Reference No:	2025/70/92338/W
Site Address:	Land at Lingards Road, Slaithwaite, Huddersfield, HD7 5HY
Description:	Variation of condition 2 (plans) on previous permission 2020/93954 for erection of 42 dwellings and associated works
Recommending Officer:	Katie Chew

DECISION – Section 73 Variation of Condition – Approve

Officer Report

Proposal: Variation of condition 2 (plans) on previous permission 2020/93954 for erection of 42 dwellings and associated works.

drawing no.: rev:
2510-PL-SL-050 -

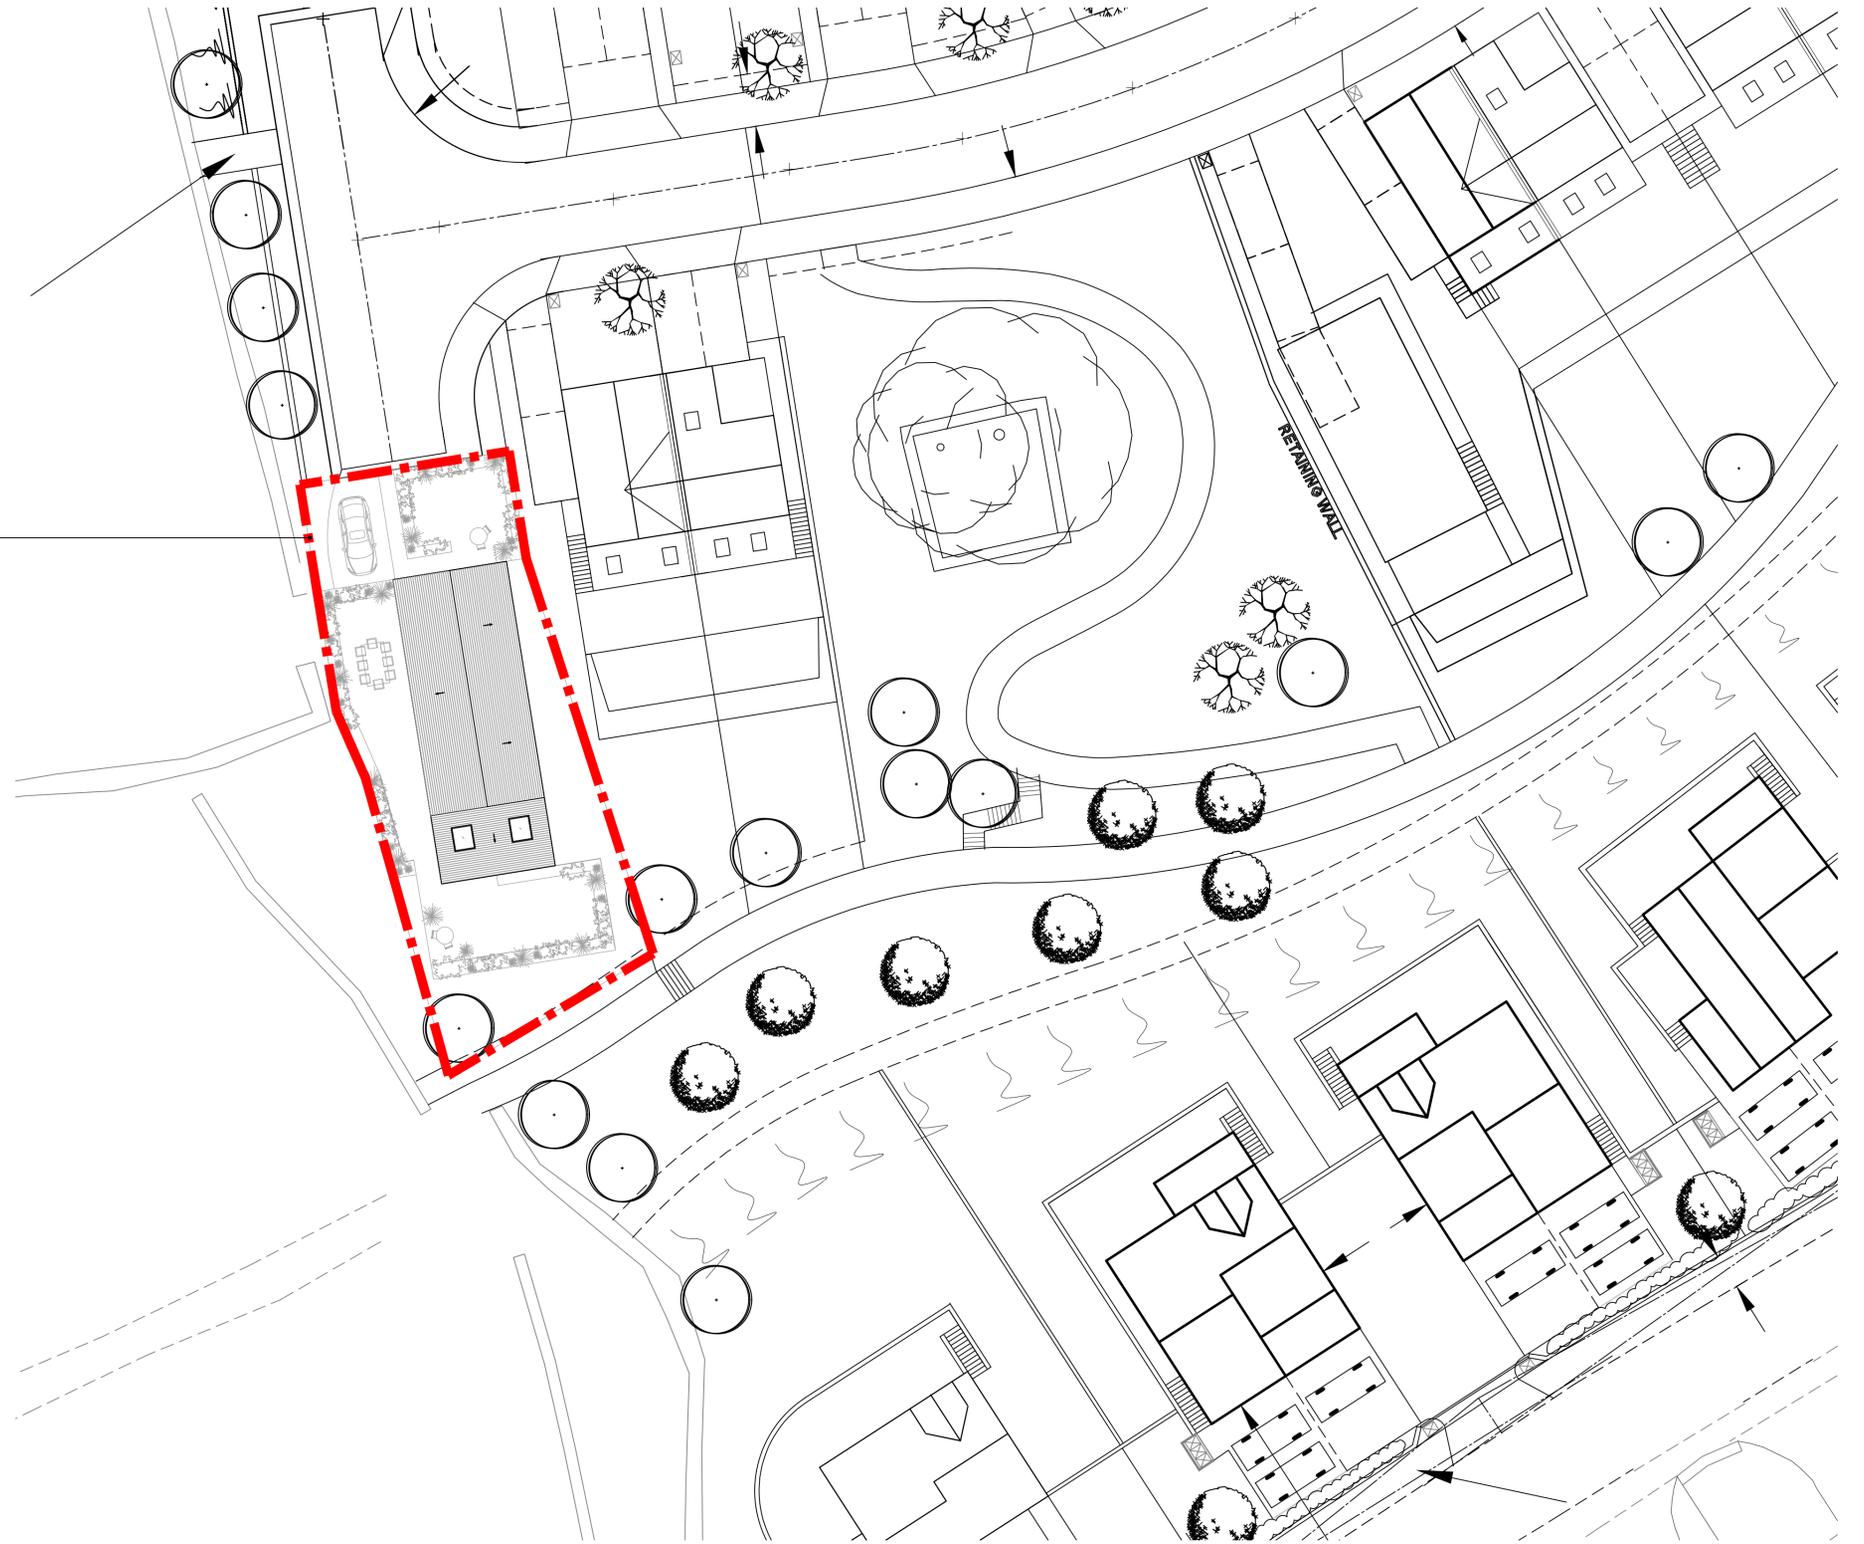
This proposal is for a revision to Plot 24; the proposals are to amend the layout / design of plot 24, located to the western boundary of the site. The proposals change the approved 4 bedroomed detached house with two off-street parking spaces and integral single garage to a 4 bedroomed detached house with attached single garage and two parking spaces.

KC Highways Development Management have been consulted on the proposals and whilst they do not object to the scheme, they did require amendments to be made to ensure that three off-street parking spaces are provided, to accord with the requirements for a 4-bedroomed dwelling, within the Kirklees Highways Design Guide SPD. As originally submitted a driveway that would only accommodate a single vehicle was proposed.

Amended plans have since been provided which enlarged the driveway, to be able to accommodate two-vehicles (with the third space in the garage being retained). The proposed variation is considered to have no other implications upon the highway. Therefore, the development is considered to be acceptable and accord with LP21 and LP22 of the Kirklees Local Plan and Chapter 9 of the NPPF.

REV	Comment	date	project	title	REV
R01	Additional car park space added	25.09.19	Lingard Road, Slaihwate	Overall Site Masterplan	R01
			Plot 24	drawing status:	
			client:	Planning	
			SB Homes	drawing no.:	
			scale:	1:200	
			sheet:	A1	
			date:	August 2025	
				2510-PL-SL-050	
				-

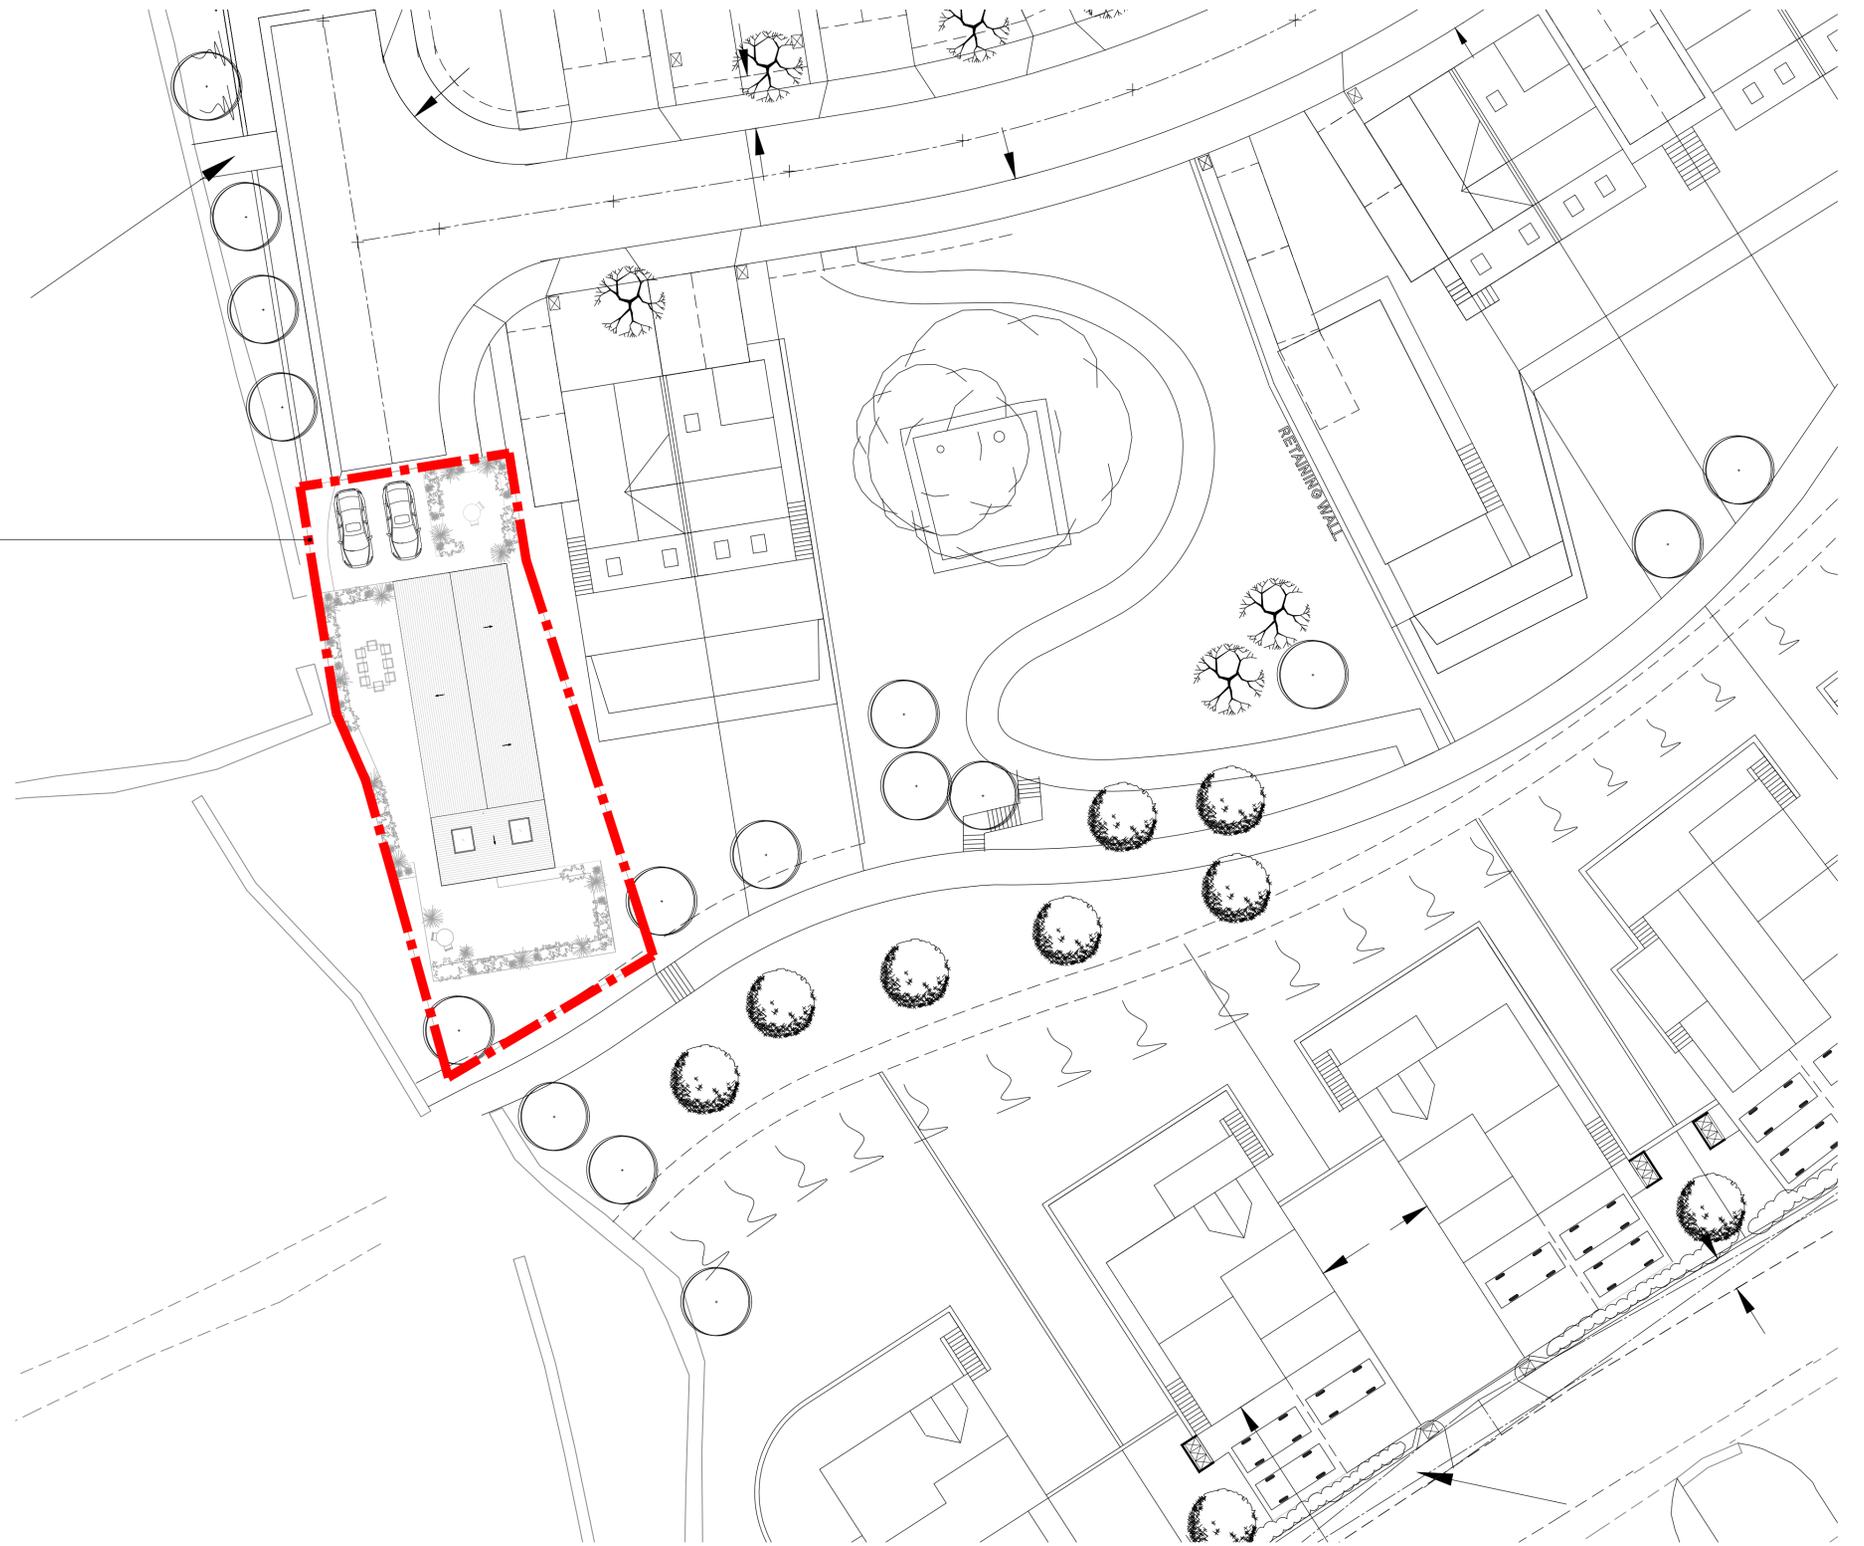
KC Highways Development Management – Initial concerns were raised by KC Highways due to a lack of suitable off-street parking. Amended plans were submitted by the applicant, which seek to provide 3 off-street parking spaces, in line with the Kirklees Highways Design Guide SPD for 4+ bedroomed dwellings.
